## BULLETIN No. 3

Date: February 5, 2013  
To: Allied Cook  
RE: TSL Building - Showroom and Service Bay Additions  
Portland, Maine  
JHN #: 2008-279.3

2 WALL SECTION
A300 A310 SCALE: 3/4" = 1'-0"

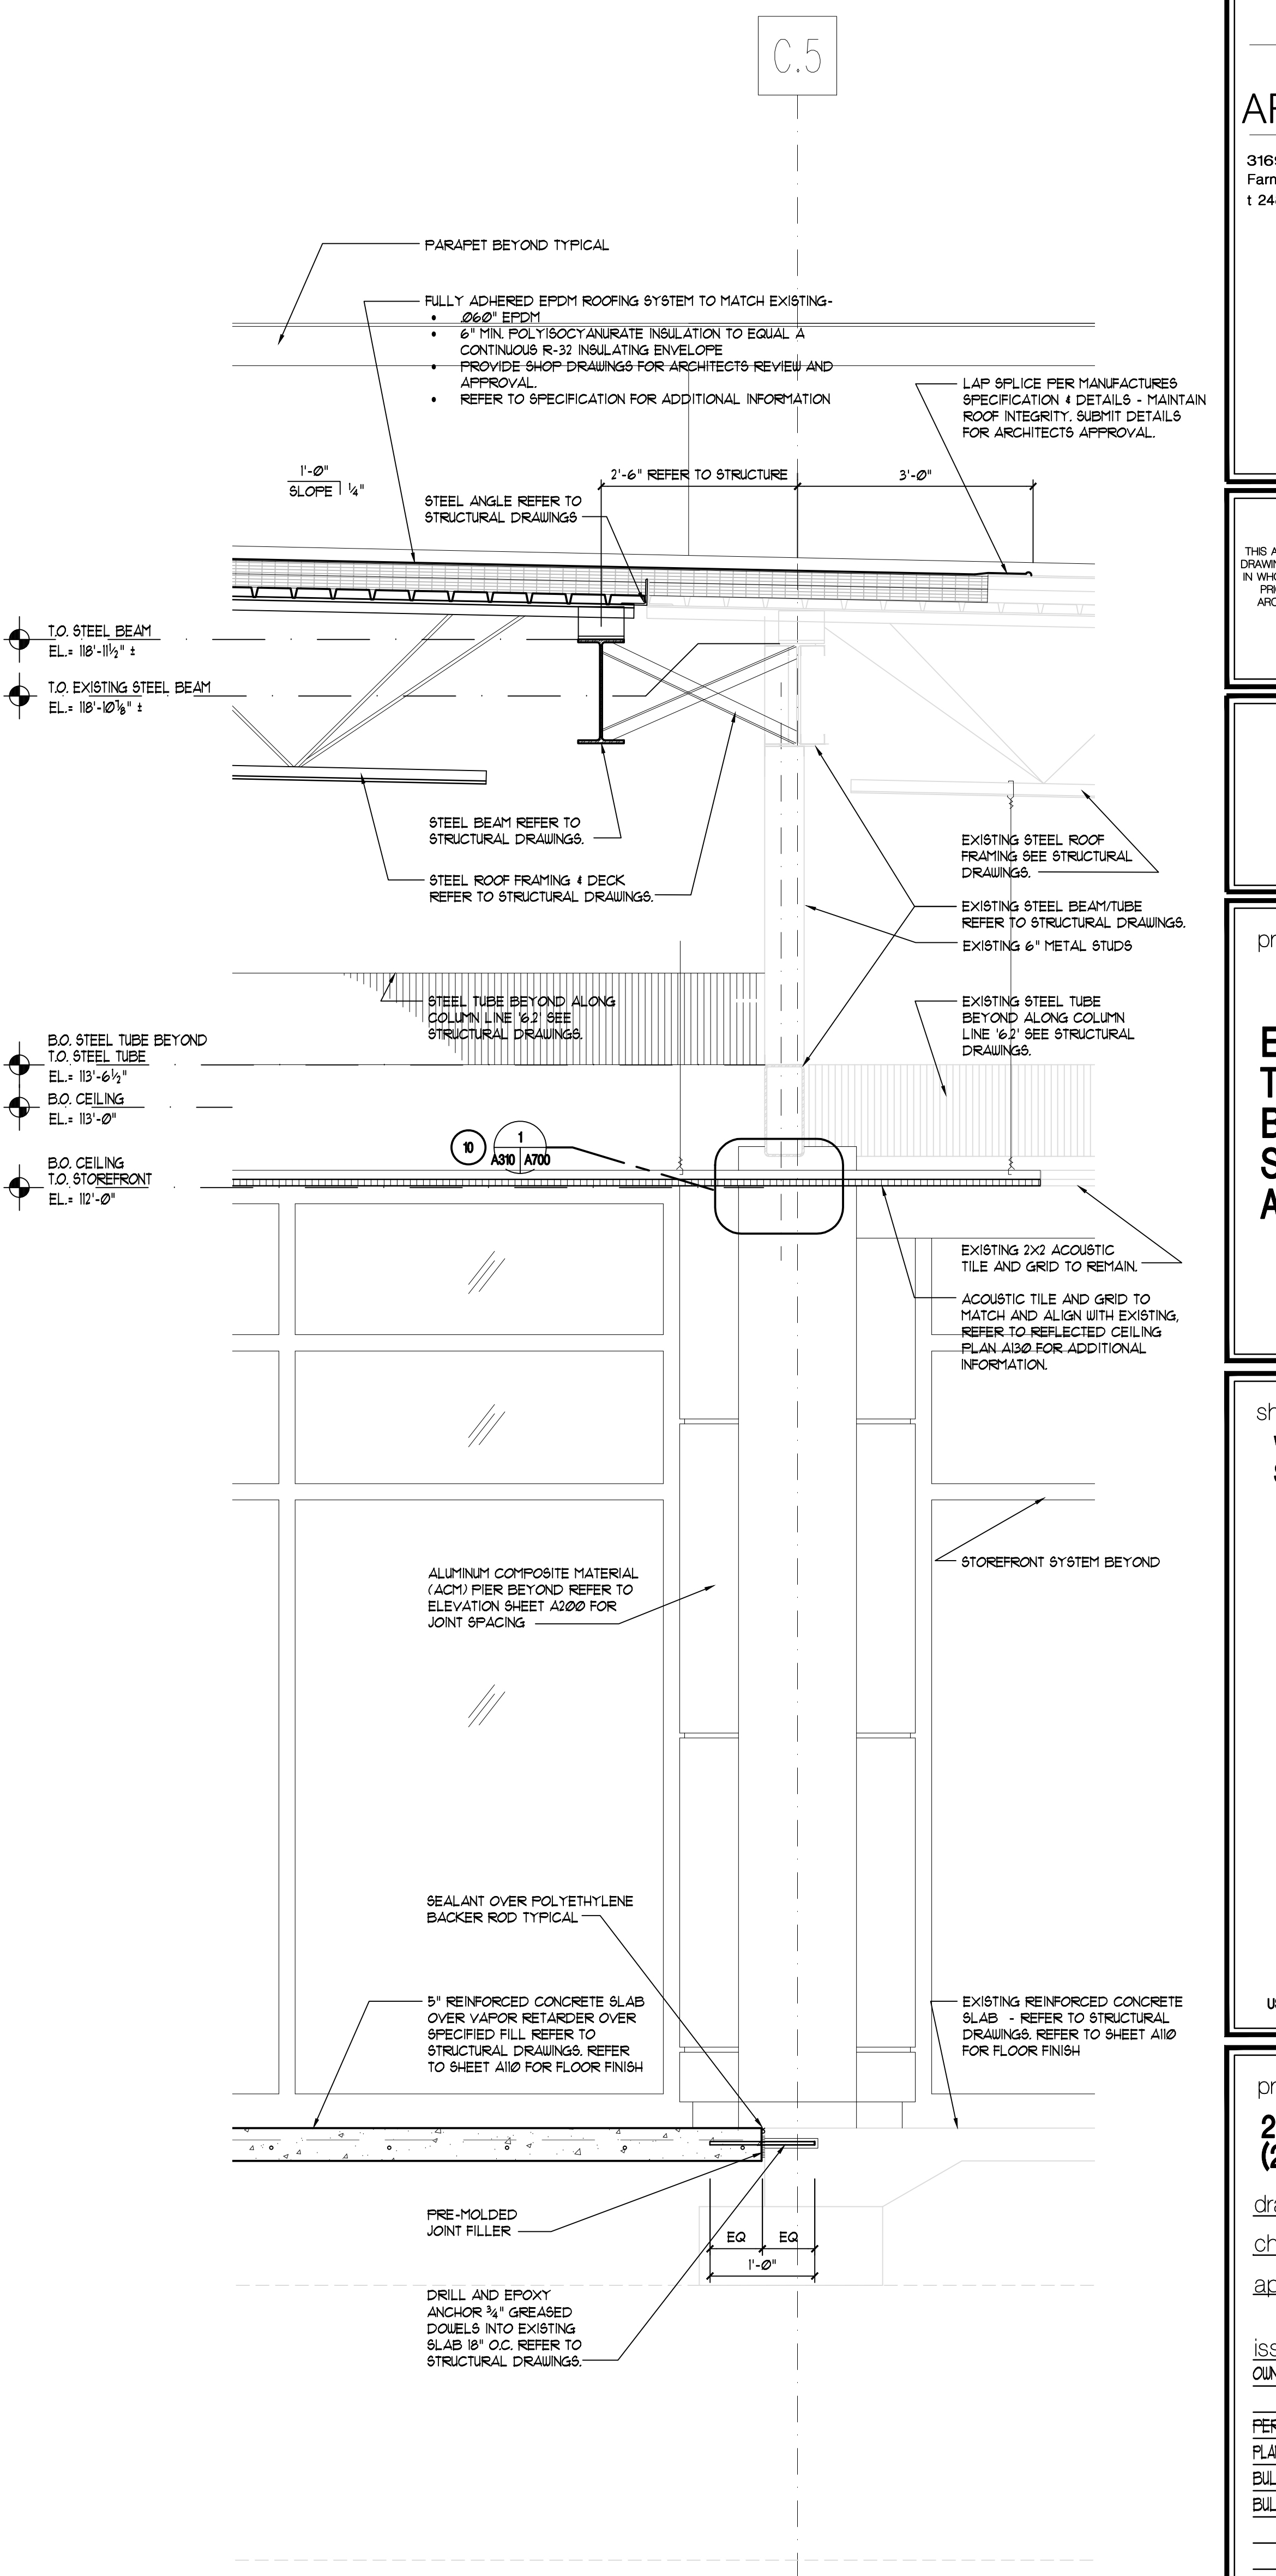
Item 2.5 Refer to Sheets A300, A301, A311, A320

- *Revised sections based on new configuration, walls etc.*
